**Consultation Response from KC,
Highways Development Management**
2021/92462 rear of, 1091, Manchester Road, Linthwaite, Huddersfield, HD7 5LS
Outline application for erection of detached dwelling
Date Responded: 21/07/21 Responding Officer: J Turner Responding Ref: K1-42/38

This application seeks outline approval for the erection of a detached dwelling at Manchester Road, Linthwaite. All matters are reserved at this stage, so only point of access is considered at this stage.

STATUS			PROVISIONAL		
PROJECT			LAND OFF 1091 MANCHESTER ROAD		
TITLE			PROPOSED		
CLIENT			P.WHITING		
DRAWN BY	CHECKED BY	DATE			
Author	Checker	12.05.2021			
SCALE (@ A1)		PROJECT NUMBER			
As indicated		HD.20.33			
DRAWING NUMBER				REV	
HD.20.33.01

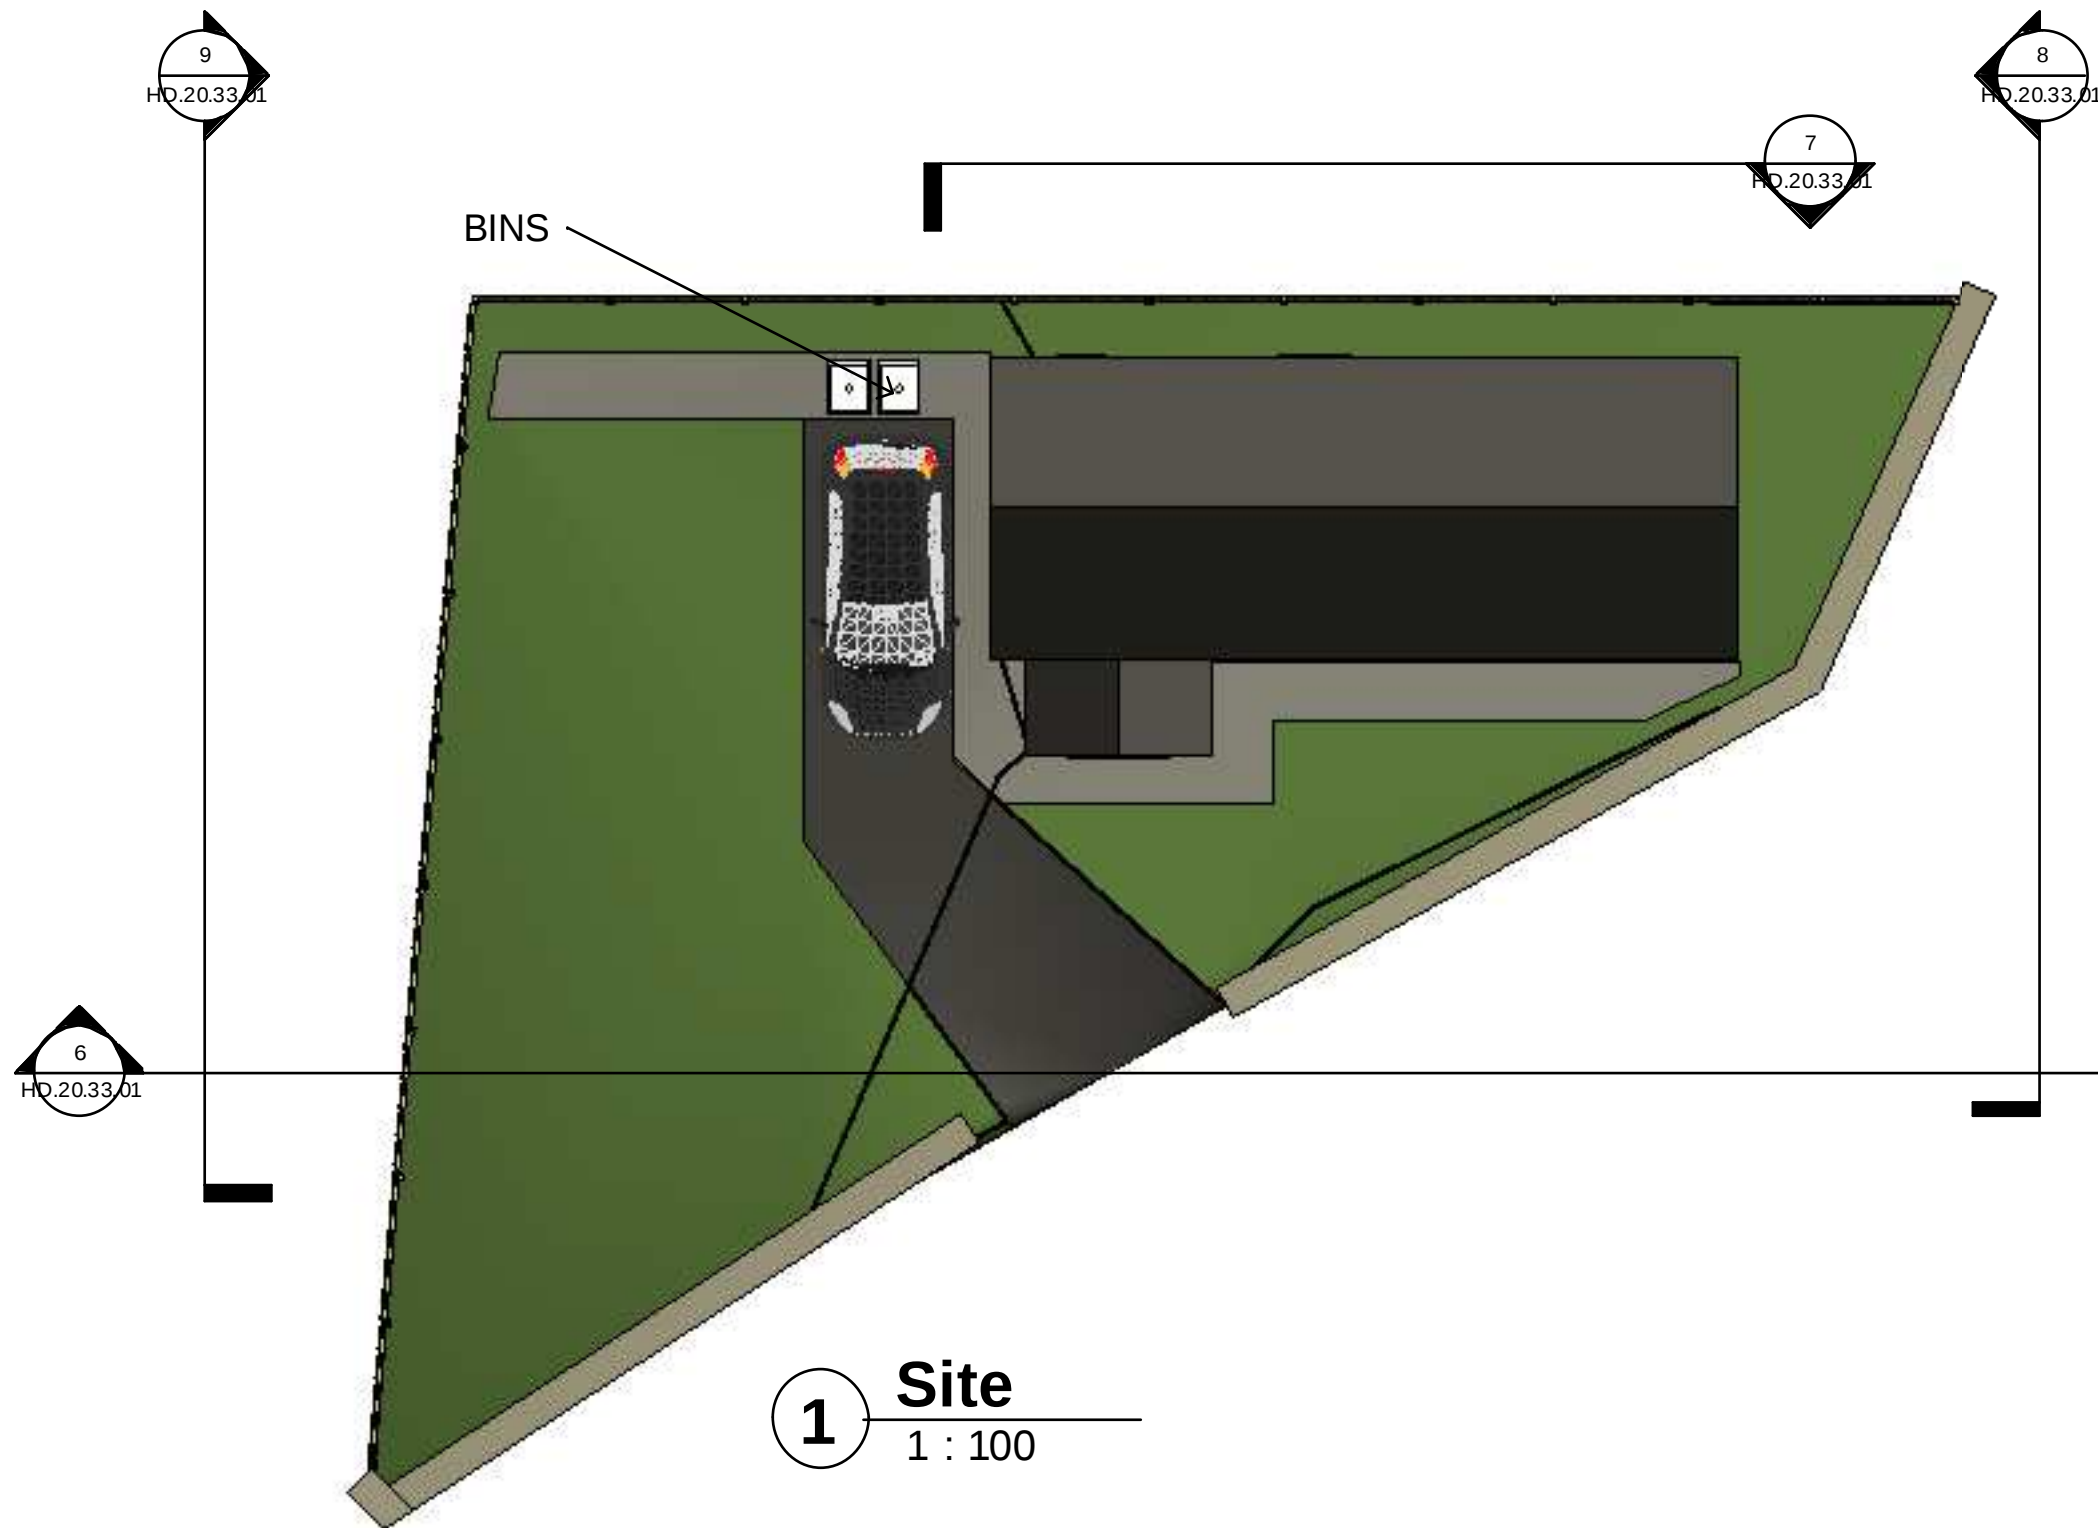
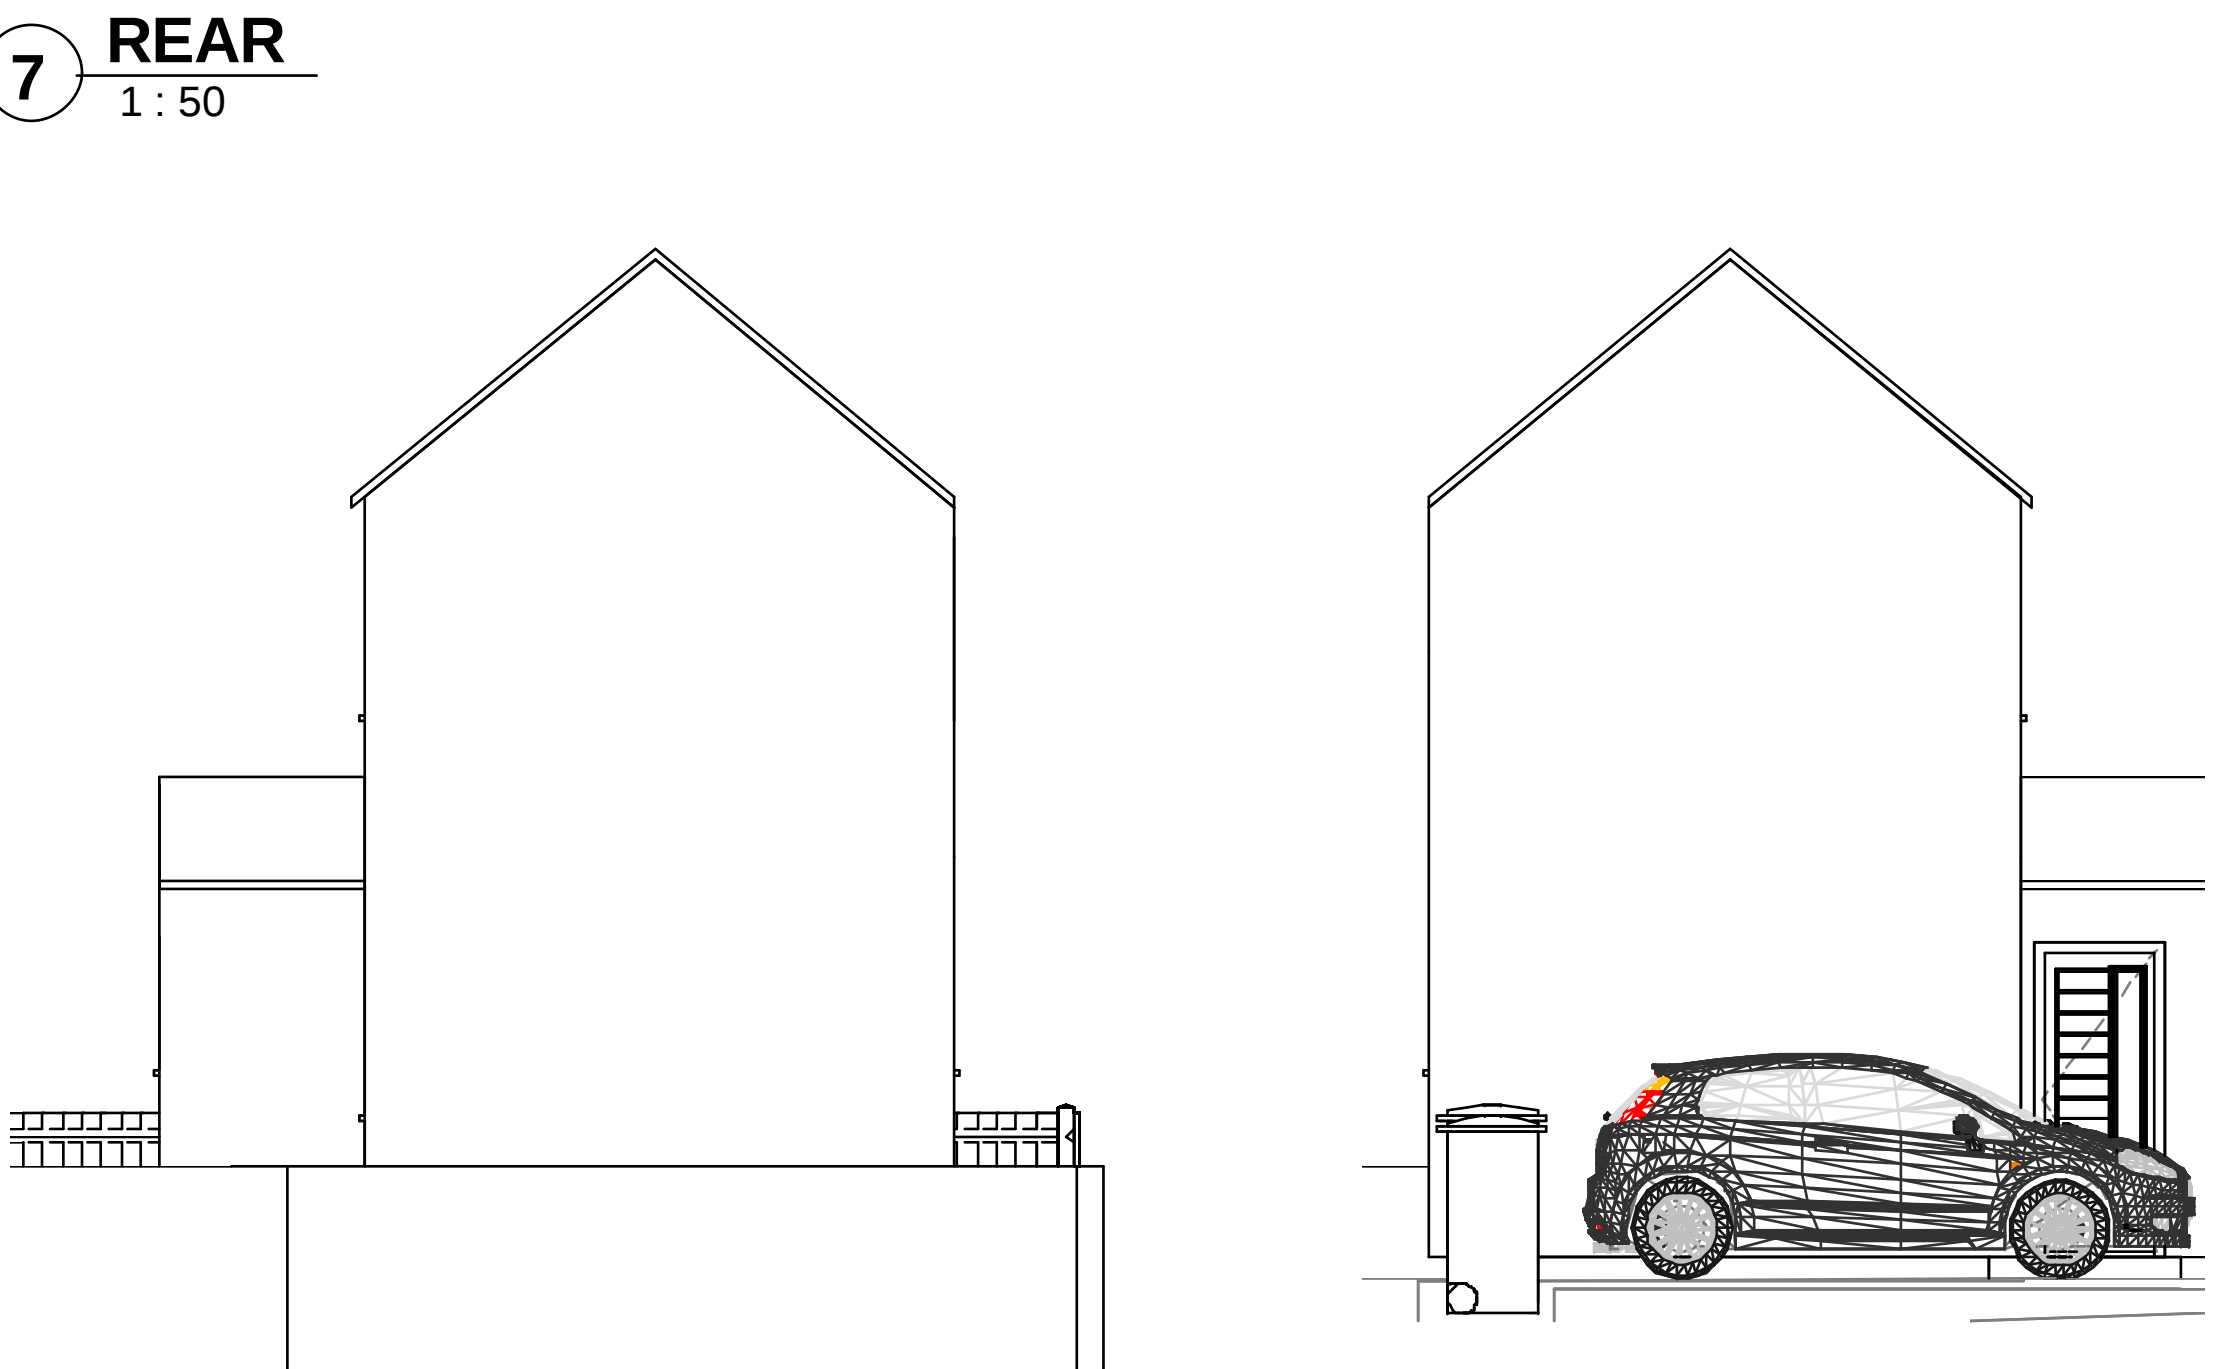
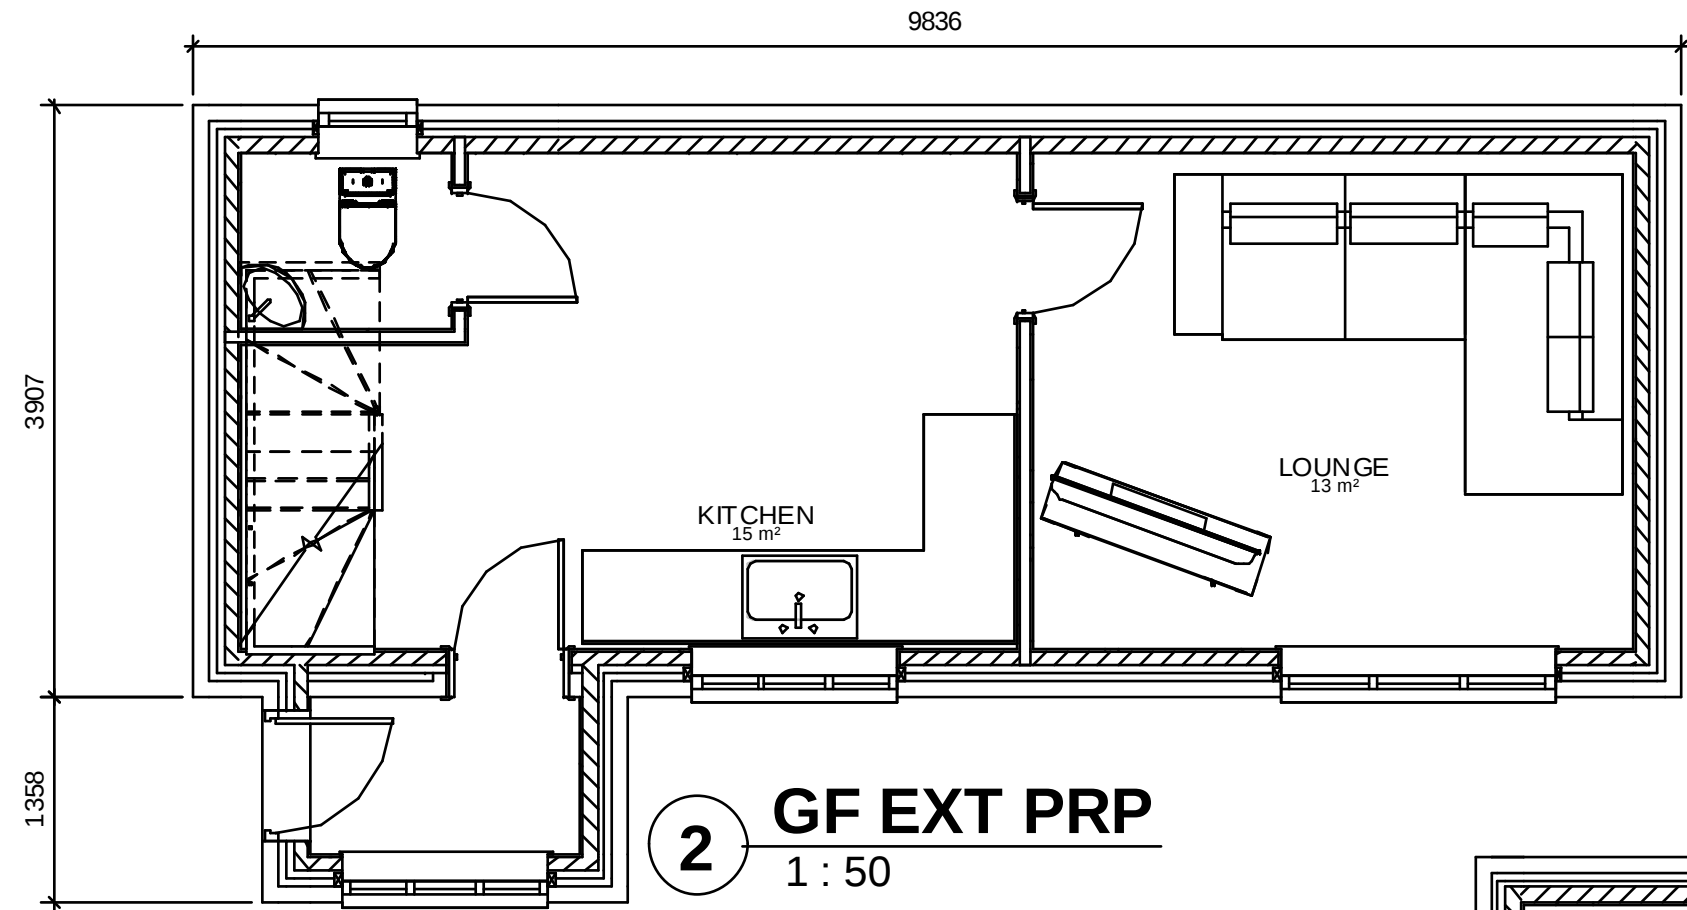
An indicative layout submitted by the applicant shows a two-bedroomed dwelling with two off-street parking spaces provided. Bin storage is also shown, with adequate driveway space to allow for collection from the carriageway edge.

The site takes access onto the public highway via Linfit Fold. Although internal vehicle turning is not provided, the access is taken from Linfit Fold; as this is not a classified highway, it is not essential to provide the ability to access and exit in a forward gear.

The indicative layout is acceptable from a highways perspective, however, the parking arrangement is only suitable for a dwelling of three bedrooms or fewer, so Highways DM would expect this level of living space to be retained should a reserved matters application be forthcoming.

Notwithstanding the details shown on the approved plan, no development shall take place until a scheme detailing arrangements and specification for layout and parking have been submitted to and approved in writing by the Local Planning Authority. Before any building is occupied the development shall be completed in accordance with the details shown on the approved plans and retained thereafter.

No part of the development shall be brought into use until the existing access from Linfit Fold has been permanently closed [and any redundant footway crossings removed and the footway reinstated] and the new access has been constructed and brought into use in accordance with details that have previously been approved in writing by the Local Planning Authority.

The maximum gradient of the access ramp to the car park shall not exceed 1 in 8.
